WELWYN HATFIELD COUNCIL – DEVELOPMENT CONTROL
DELEGATED REPORT

APPLICATION No:	S6/2008/0607/FP
------------------------	------------------------

The application seeks full planning permission for a single storey rear extension which would be approximately 3.2m deep and 9.3m wide.

Proposed side elevation  
(viewed from No 373)

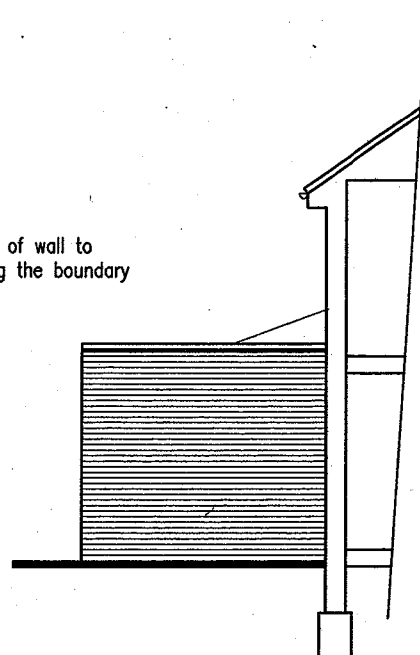
Turning to No.373, this is the semi-detached dwelling which is the mirror image of the application dwelling, and the rear of this neighbours property has not been extended. A 1.5m close-boarded fence is the current common side boundary treatment to this neighbours dwelling which has a terrace area directly in front of full height glazed patio doors.

The proposed extension will be approximately 0.6m away from the edge of this glazed patio door and the flank of the proposal will be directly west.

Taking into account this separation distance and orientation, it is acknowledged that there will be some shadowing to this neighbours rear terrace and loss of light to the

lounge, more so during the second half of the day, however local plan policies are not intended to preserve the existing daylight, but to ensure that a sufficient level remains.

Taking into account these factors, it is considered that the depth of proposed extension is towards its upper limits, but on balance, the proposal would not result in a significant loss of either sunlight or daylight to either the outside rear open amenity space or the patio doors to the habitable ground floor room.

In regards to the question of dominance or overbearing, it is considered that the scale and height of the flank wall would not be harmful to the aspect on this neighbours property, as it would only have a limited impact on the wider rear garden and when viewed through the patio doors.

Proposed side elevation  
(section through No 377)

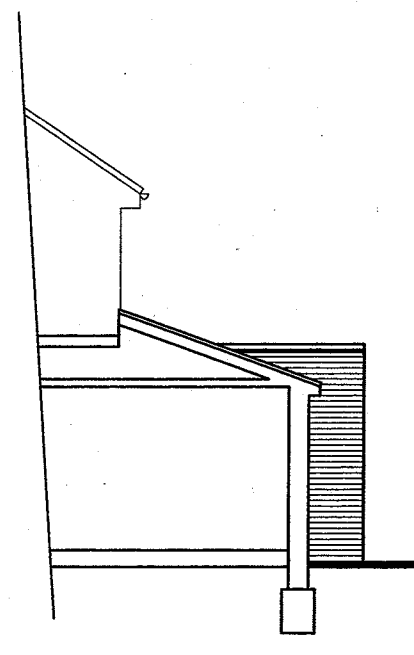
In regards to No.377, this property has already been extended with a single storey extension which projects with a blank flank wall facing the application site. The proposed extension does extend slightly beyond this, but this would have no significant impact on this neighbours amenity.

Proposed ground floor plan

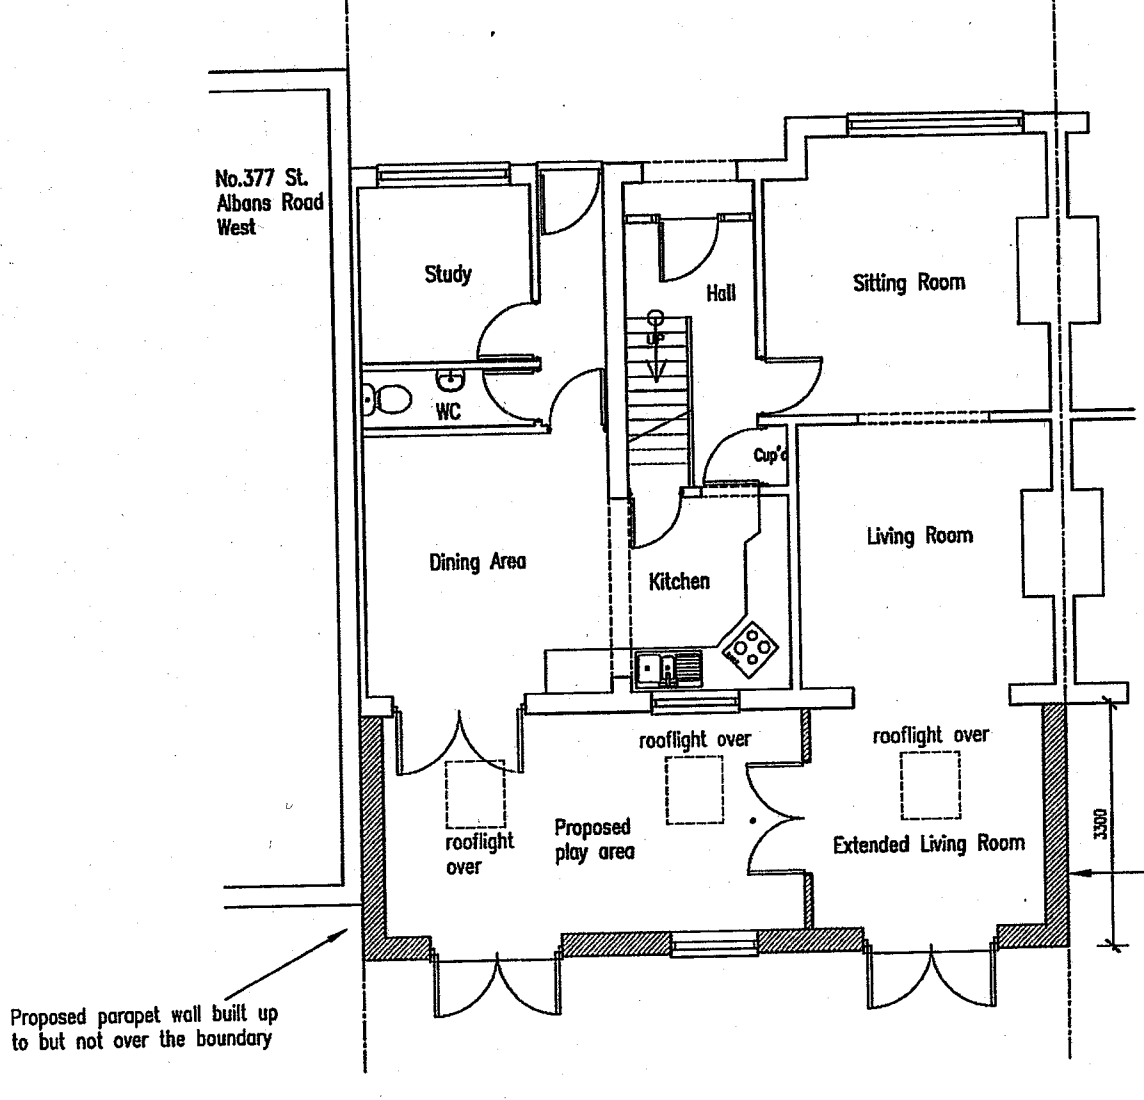
The proposed is for a rear extension which will have a flat parapet style roof similar to the current on to the side of the property and will be in matching brick work.

The proposed depth at approximately 3.2m would be in scale with the parent property and so the design of the extension complies with these design policies.
